Longfield Solar Farm

Applicant Responses to ExA Further Written Questions

Document Reference : EN010118/EX/8.15

Deadline 4

10-12 A

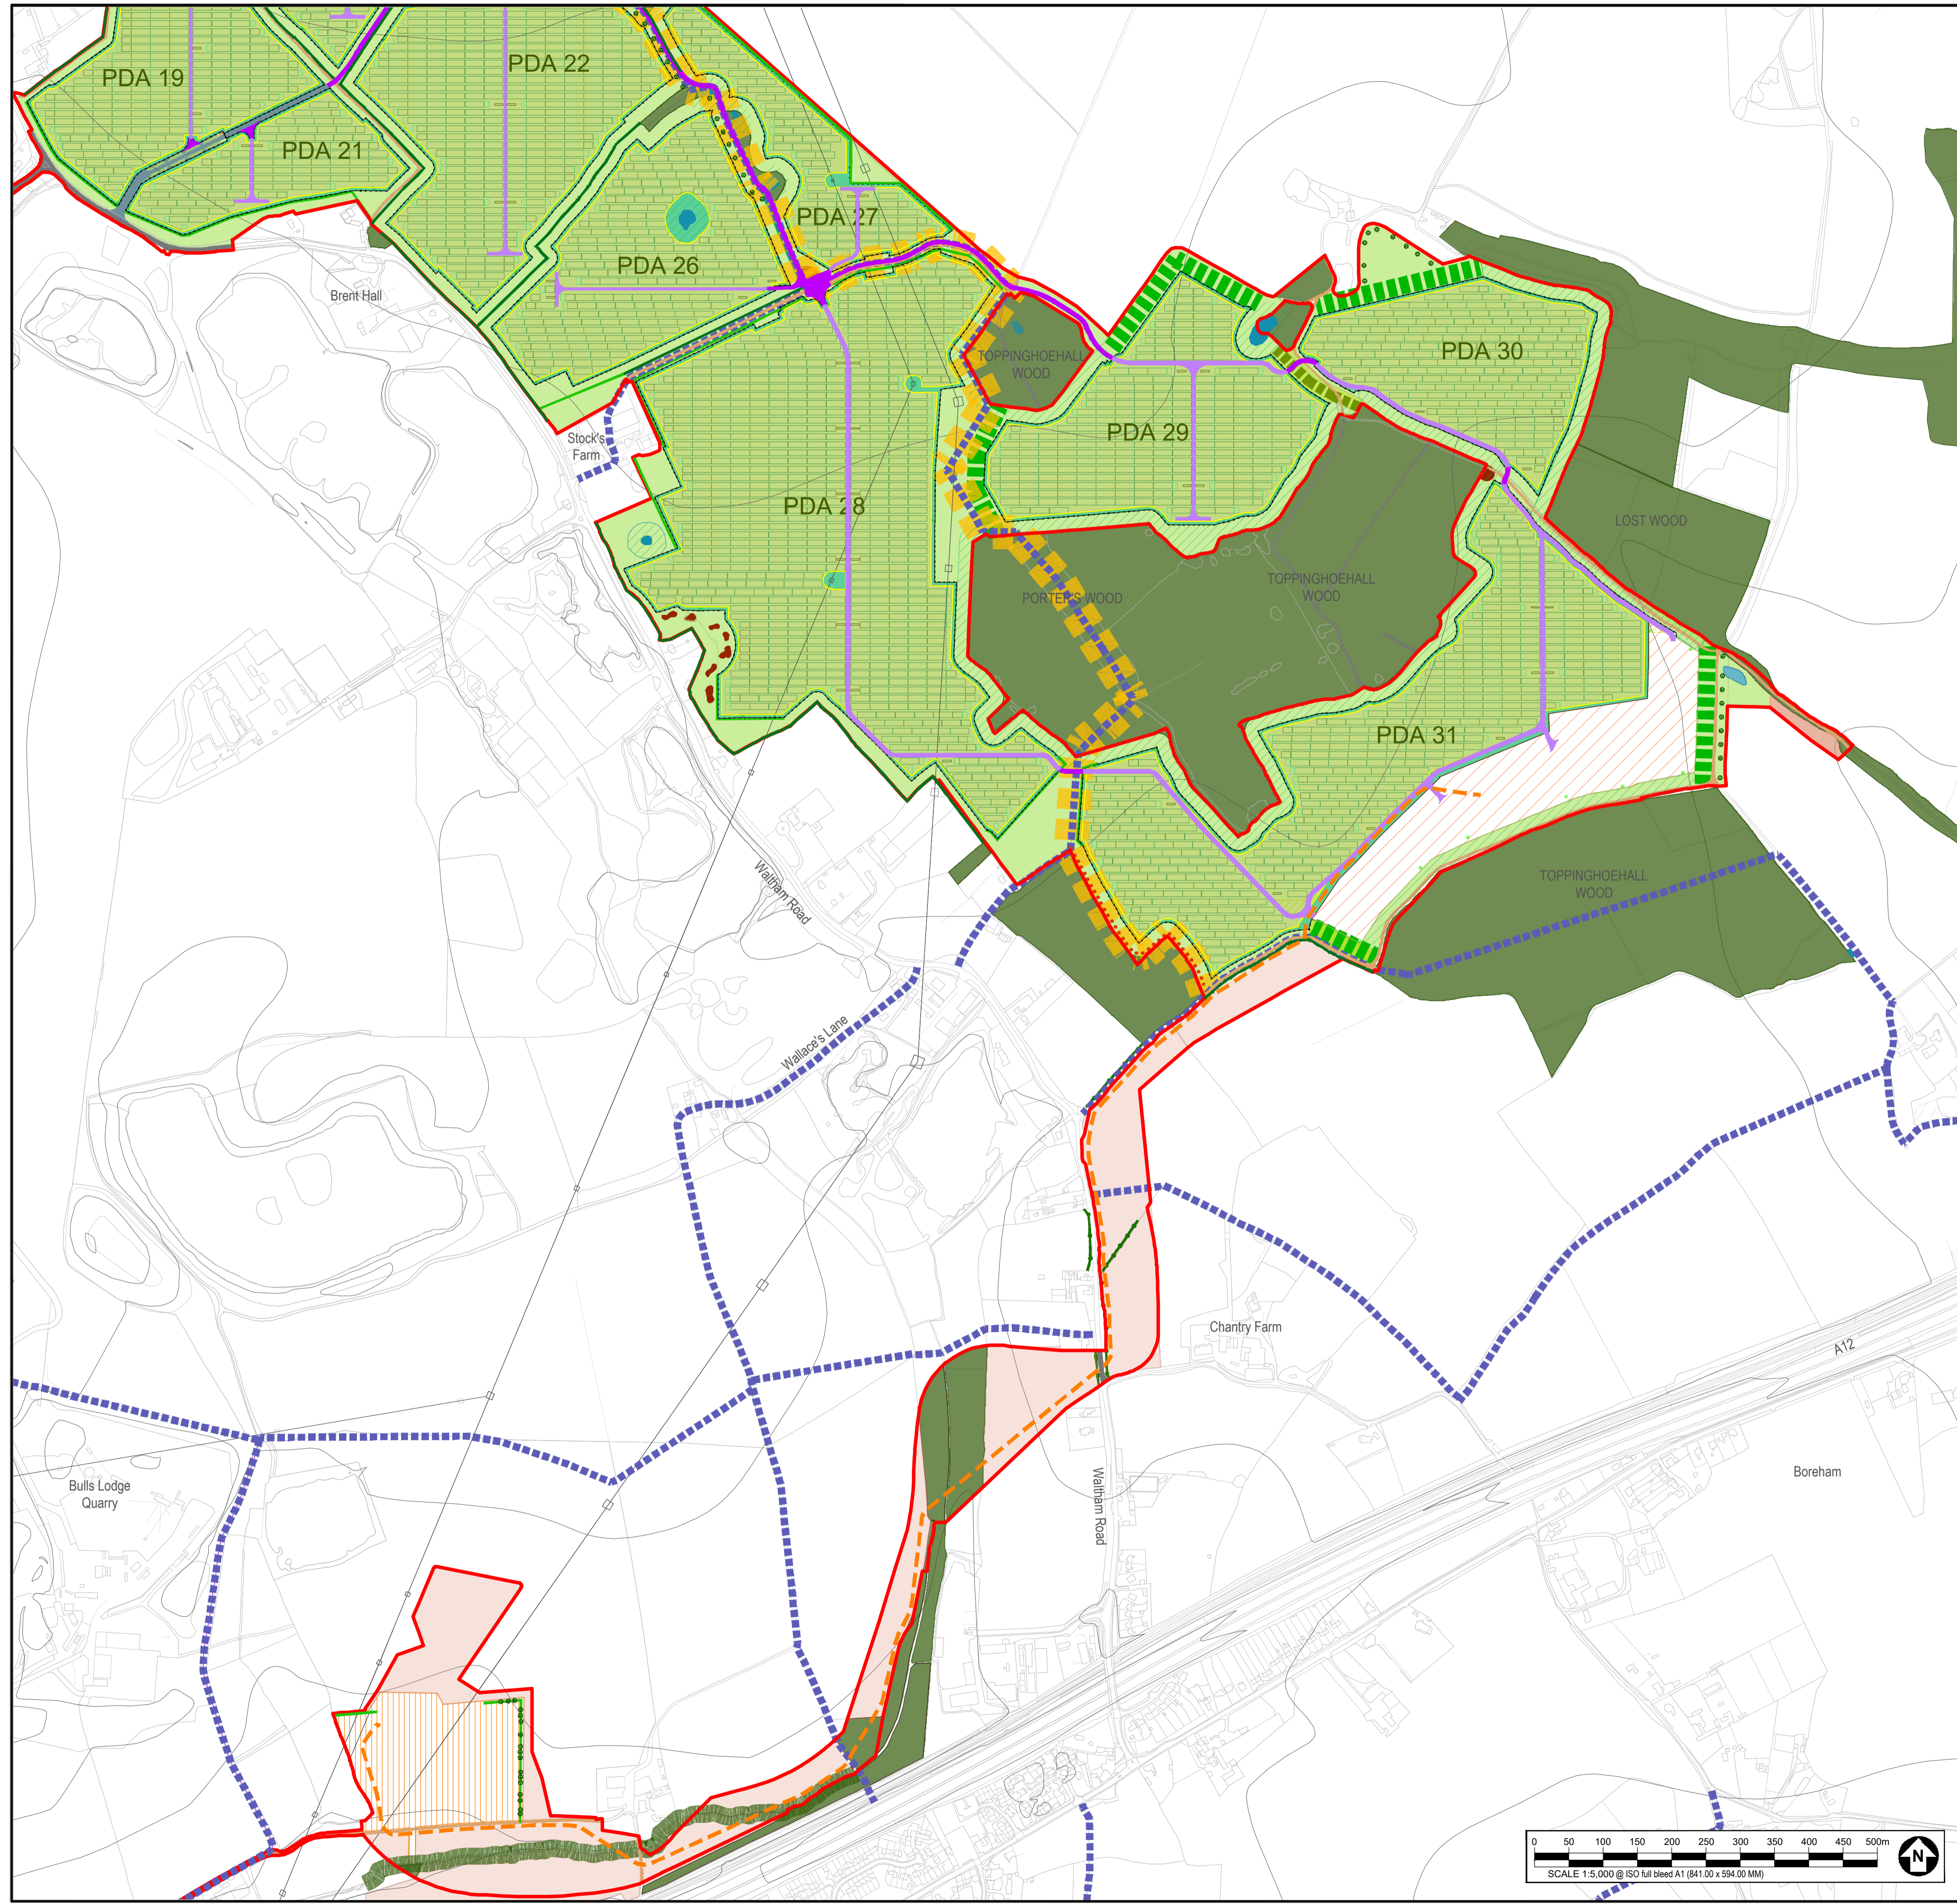
ExQ.	Respondent	Question	Applicant Response
2.8.1	Applicant	<p>Table B-20 (LVIA) of the Applicant's Response to Relevant Representations [REP1A-002], (responding to RR-48 and RR-59), states that an assessment of the proposed lighting on ecology has been undertaken in ES Figure 10-12: Outline Landscape Masterplan [APP-179].</p> <p>Please indicate where on the Outline Landscape Masterplan this assessment can be found.</p>	<p>The reference document referred to for the assessment of the proposed lighting on ecology is incorrect. This assessment has been undertaken in the Environmental Statement, Chapter 8: Ecology [EN010118/APP/6.1]. Lighting is discussed in paragraphs 8.8.12, 8.8.13 and the assessment of likely impacts and effects on relevant ecological features (designated sites, habitats and species) is shown in Tables 8-9 and 8-10.</p>

TITLE: Works Plan Sheet Overview

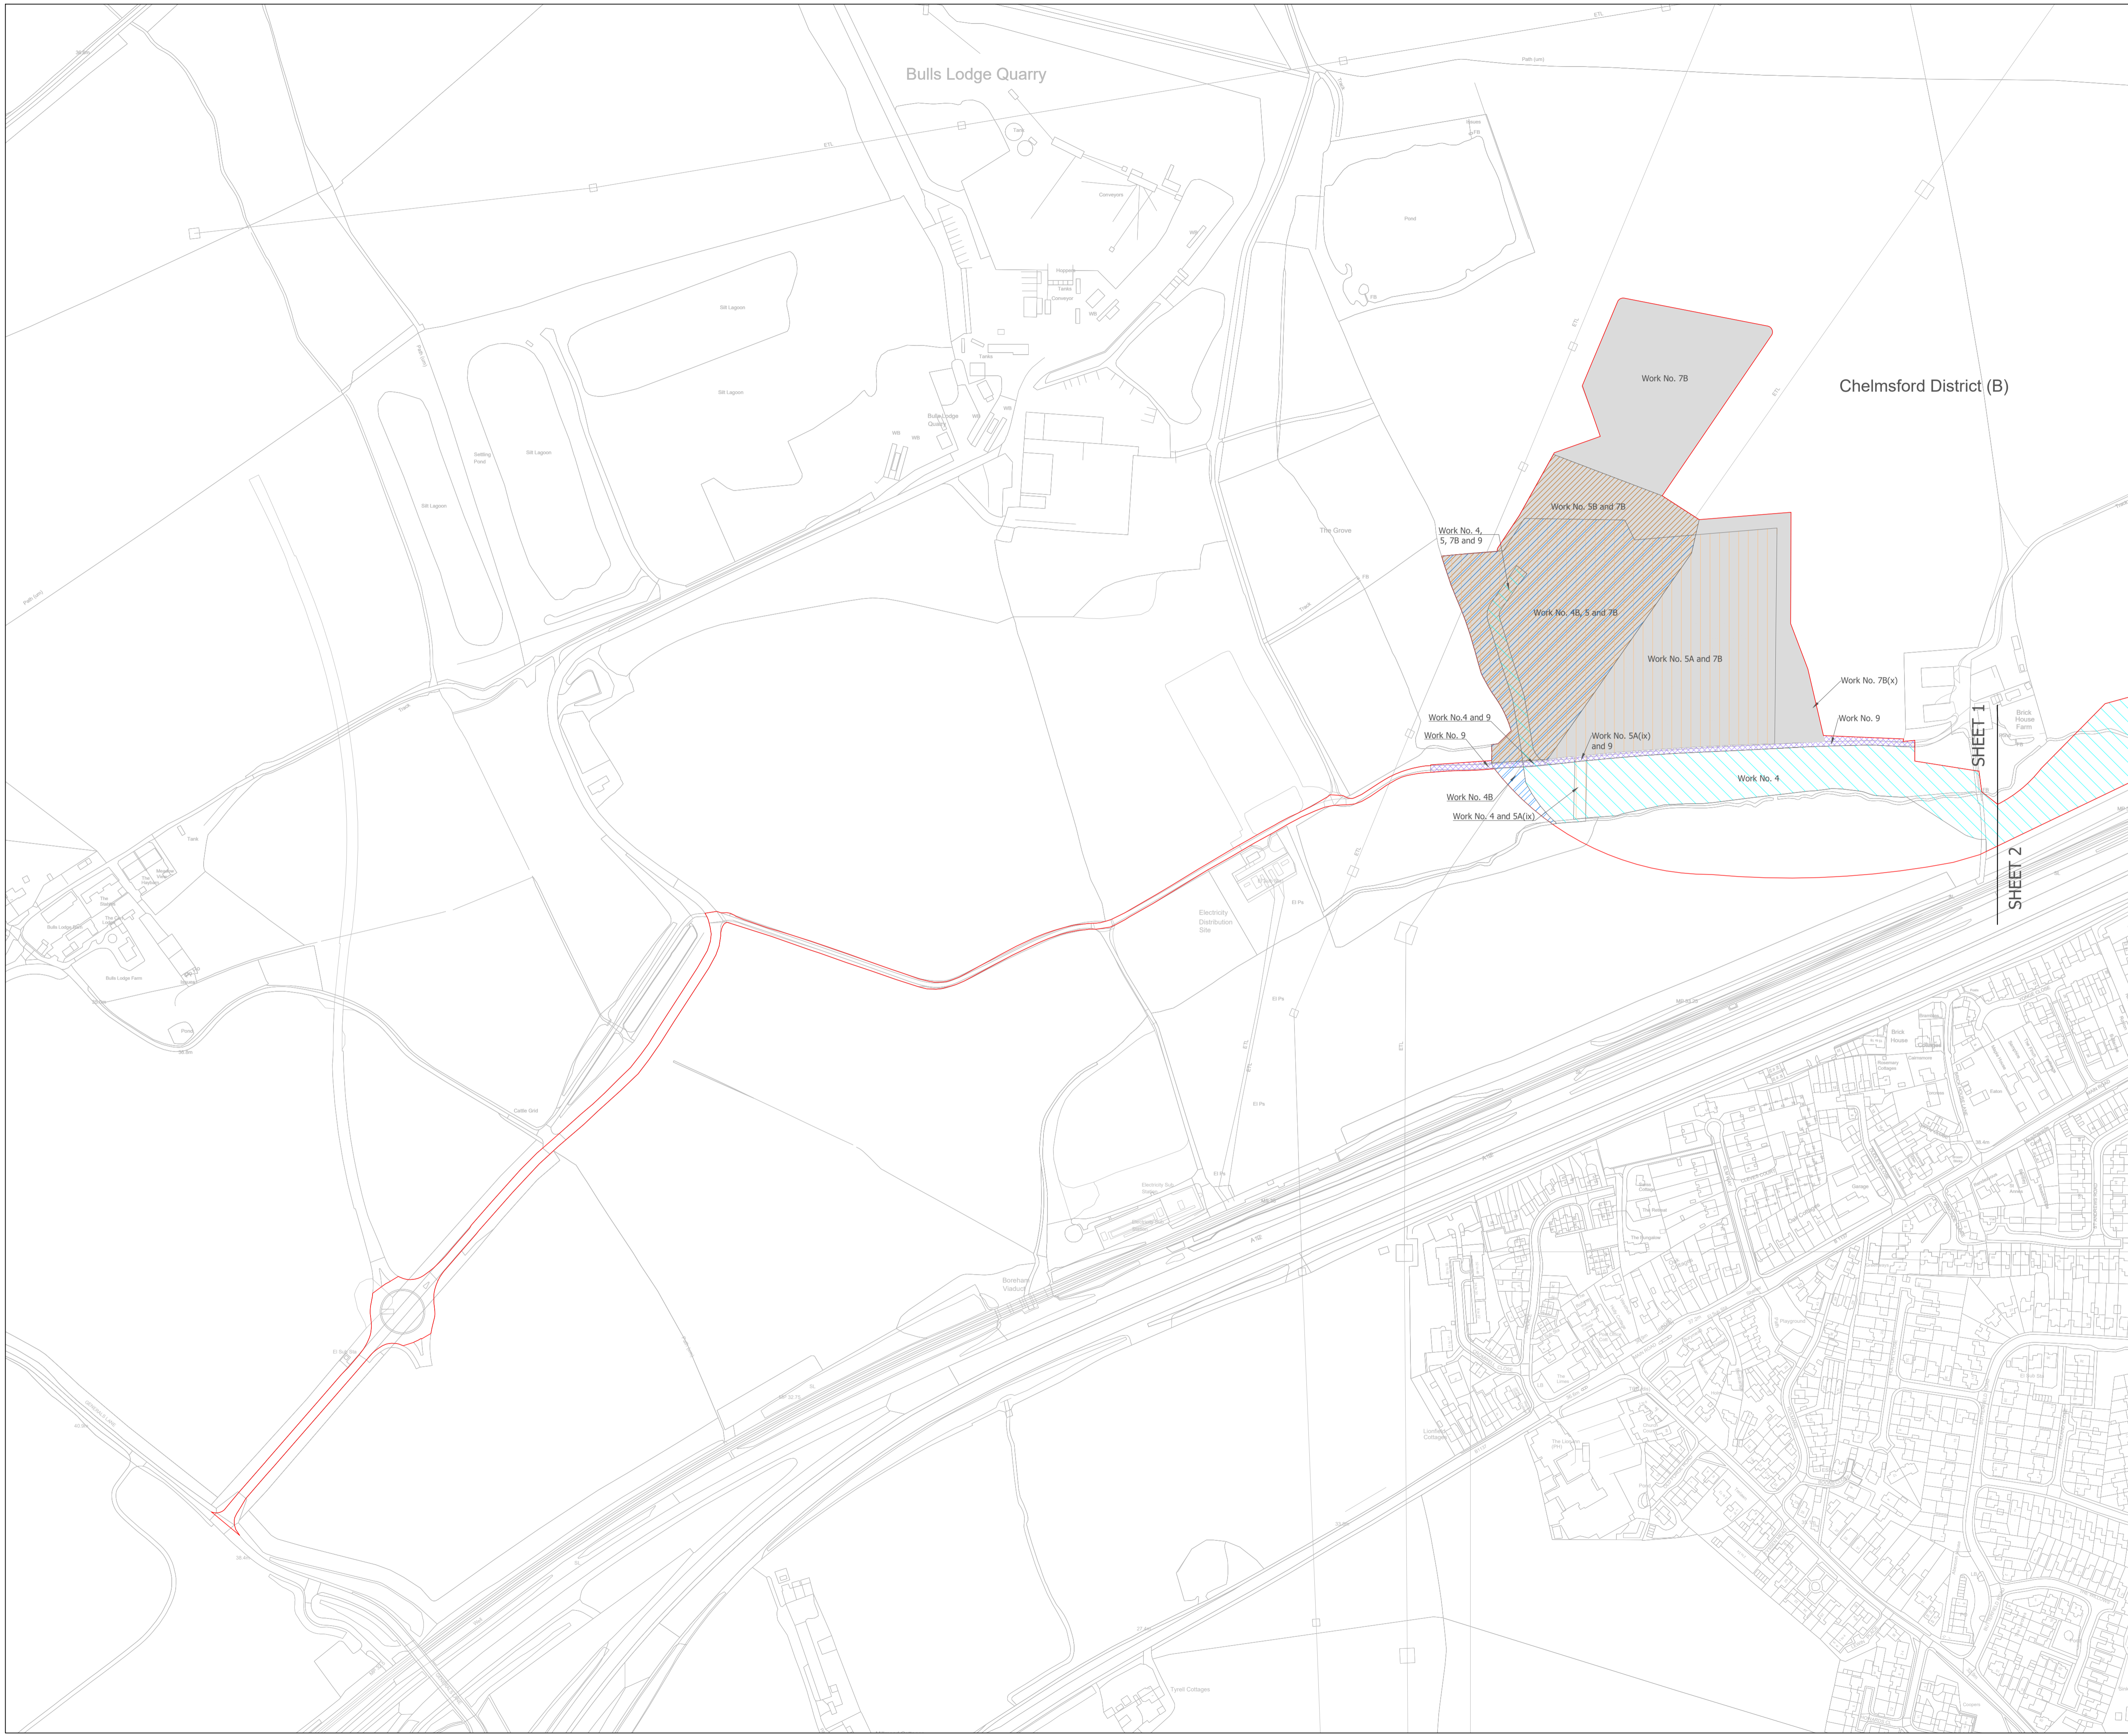
2.6.2	Applicant	<p>ES Chapter 2 (the Scheme) notes that Phase 2 of the BESS (Work No. 2B on the Works Plans) will commence operation not less than 5 years after commencement of operation of the wider Scheme and will comprise a maximum area of 1.8ha. Please can the Applicant explain whether, and if so where, this is secured in the dDCO/ODP.</p>	<p>The Outline Construction Environmental Management Plan (CEMP) details the construction programme. Requirement 13 of the dDCO requires a Construction Environmental Management Plan to be submitted and approved to the host councils, which is required to be substantially in accordance with the Outline CEMP.</p>
